File: SF16/31724
Job ID: DOC16/360068
Your Ref: SSD7545

RE: Heritage Division comments on Forensic Pathology and Coroners Court, Lidcombe (SSD7545)

EXTERNAL SIGNAGE PLAN

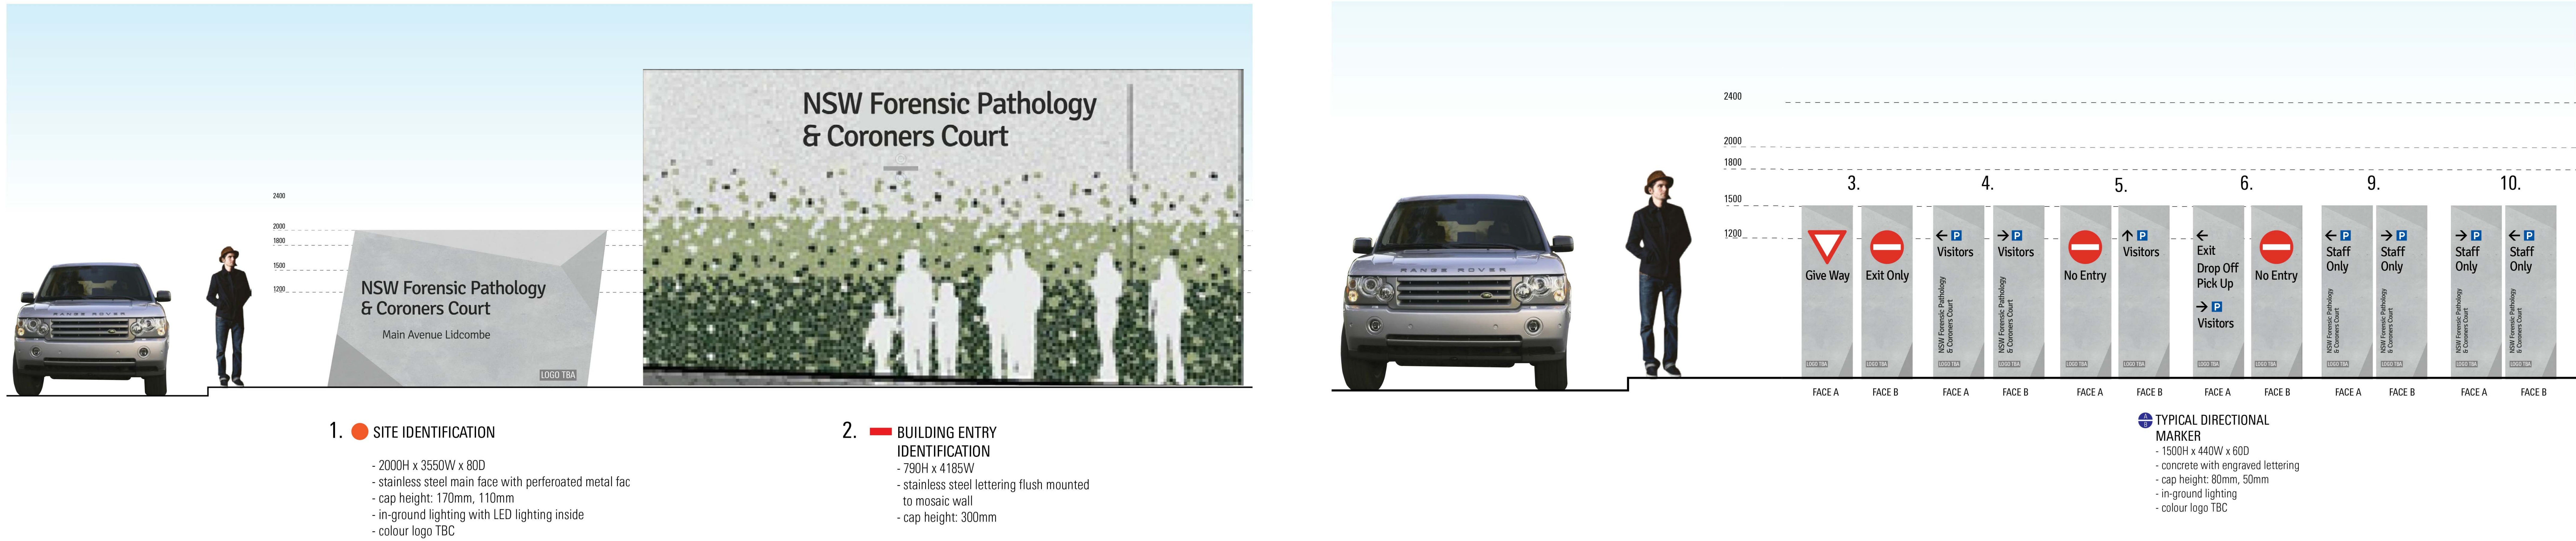
- Whilst the proposed development on the subject site would not obscure views along Main Avenue, signage could have an adverse impact on views and the character of the place and should be limited. Special consideration should be given to the design, size and location of proposed signage along Main Avenue to ensure it respects the character of the Lidcombe Hospital Precinct. Ideally the proposed large sign on Joseph Street would be removed from the proposal as it would interrupt the vegetation screening of the development on this frontage, and the main sign on Main Avenue should match the extant Botanica sign on the adjacent corner of Main Avenue and Joseph Street.

- Prior to commencement of works, a photographic archival recording of the subject site is to be undertaken and submitted for review and approval by the Heritage Division. The archival recording must be prepared by a suitably qualified and experienced heritage consultant in accordance with the Heritage Division guidelines entitled, *Photographic Recording of Heritage Items using Film or Digital Capture*. Special attention is to be paid to landscape elements to be removed (trees and kerb/ gutter).
- Signage along Main Avenue should be limited. Consideration should be given to using only the sandstone wall on the corner of Main Avenue and Joseph Street for major signage, and be of a complementary character and scale to the adjacent Botanica signage. Any additional directional signage must be carefully designed and located to not impact any views along Main Avenue.

- Signage should not be installed along Joseph Street, to limit the visual intrusion on the streetscape.
- An interpretation strategy should be developed to help convey the history and significance of the site as part of the former Lidcombe Hospital and submitted for approval to the Secretary, Department of Planning and Environment and the delegate of the Heritage Council of NSW. The approved interpretation strategy should be implemented prior to project completion and occupation of the facility.
